CITY OF ALBUQUERQUE

July 18, 2018

RE: **McMahon Carwash**
McMahon and Fineland NW
Grading Plan Stamp Date: 6/20/18
Drainage Plan Stamp Date: 6/20/18
Hydrology File: A11D016A

Based on the submittal received 7/10/18, the Grading Plan and Drainage Report cannot be approved for until the following are corrected:

Site Grading and Drainage Plan

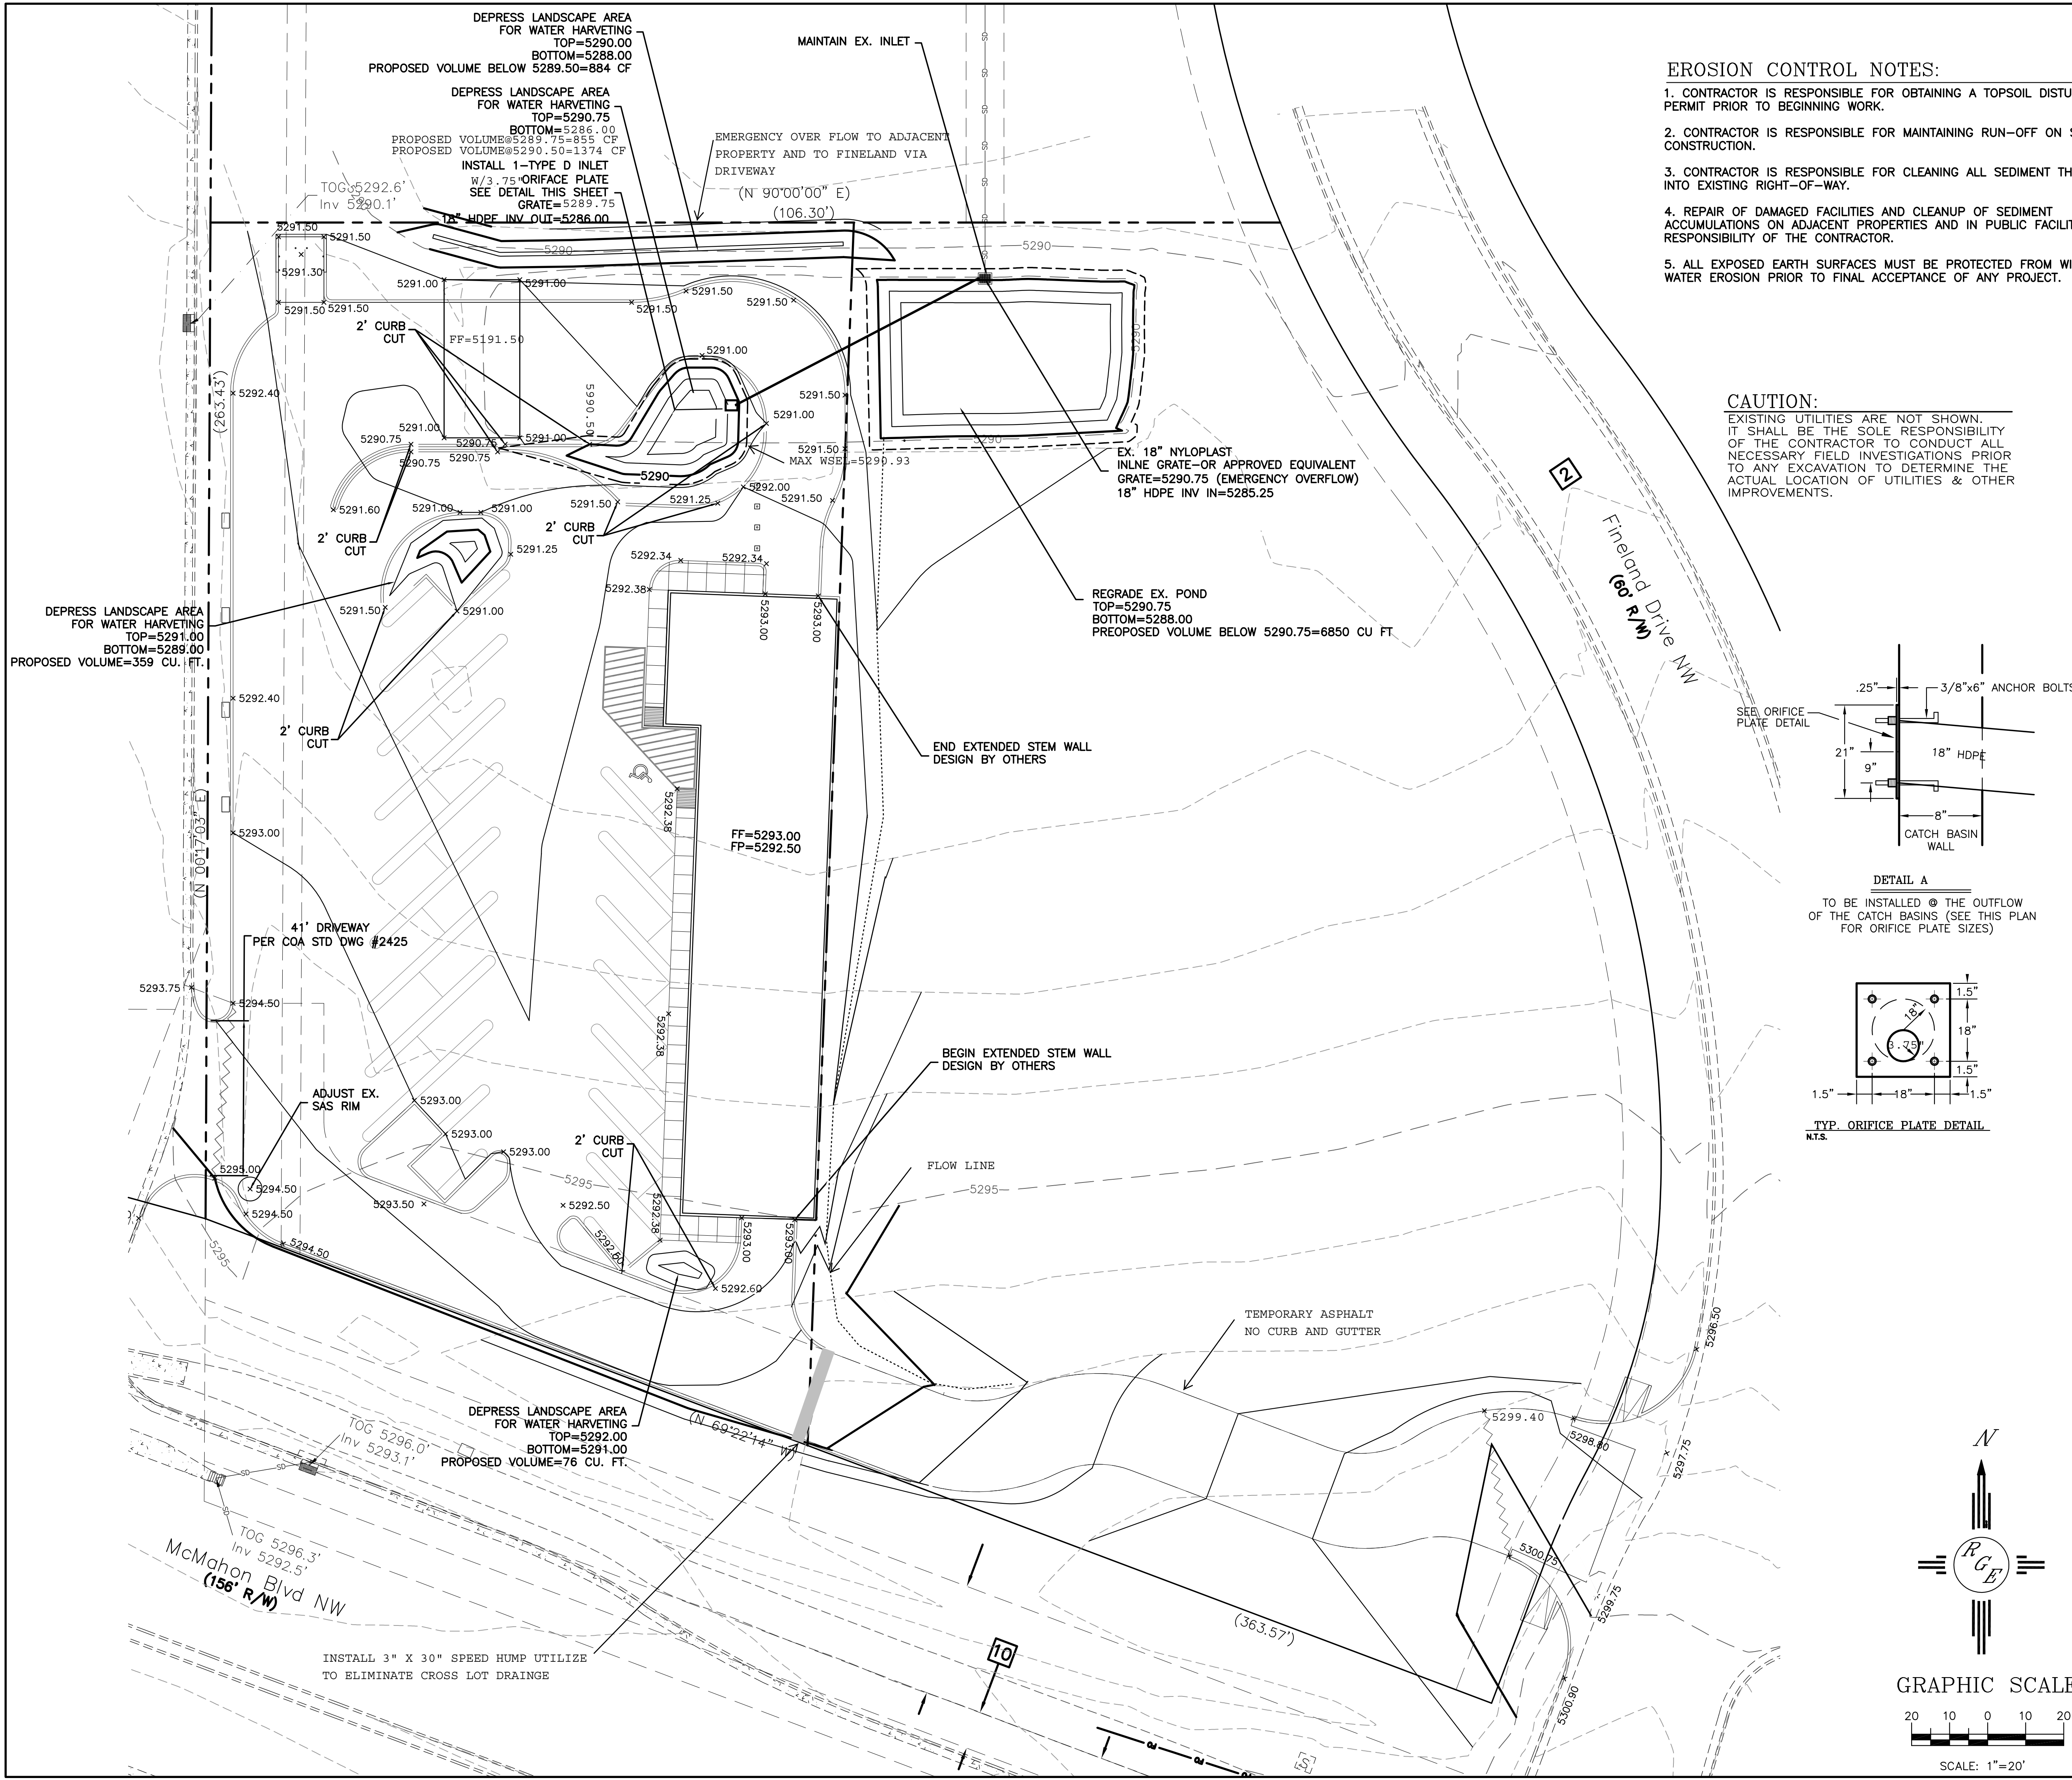
1. The first flush retention areas need to be clarified. The 4 small ponds in West Basin do not adequately capture the required volume. The north pond is higher than the parking lot and nothing seems to drain to it. The center pond has the grate elevation set at the bottom of the pond, so no dead storage is provided. The area draining to the 2 south ponds needs to be quantified, and the ponds sized to retain this first flush volume.

2. Provide minor contour labels and define spot elevations (top of curb, flowline, etc...). The spot elevations don't appear to agree with the proposed contours and it is difficult to see where the emergency overflows will go if the orifice plate clogs.

3. The elevations used in the volume calculations and orifice plate sizing (appendix B) do not match those on the grading plan. Please correct and show the max water surface elevation on the grading plan.
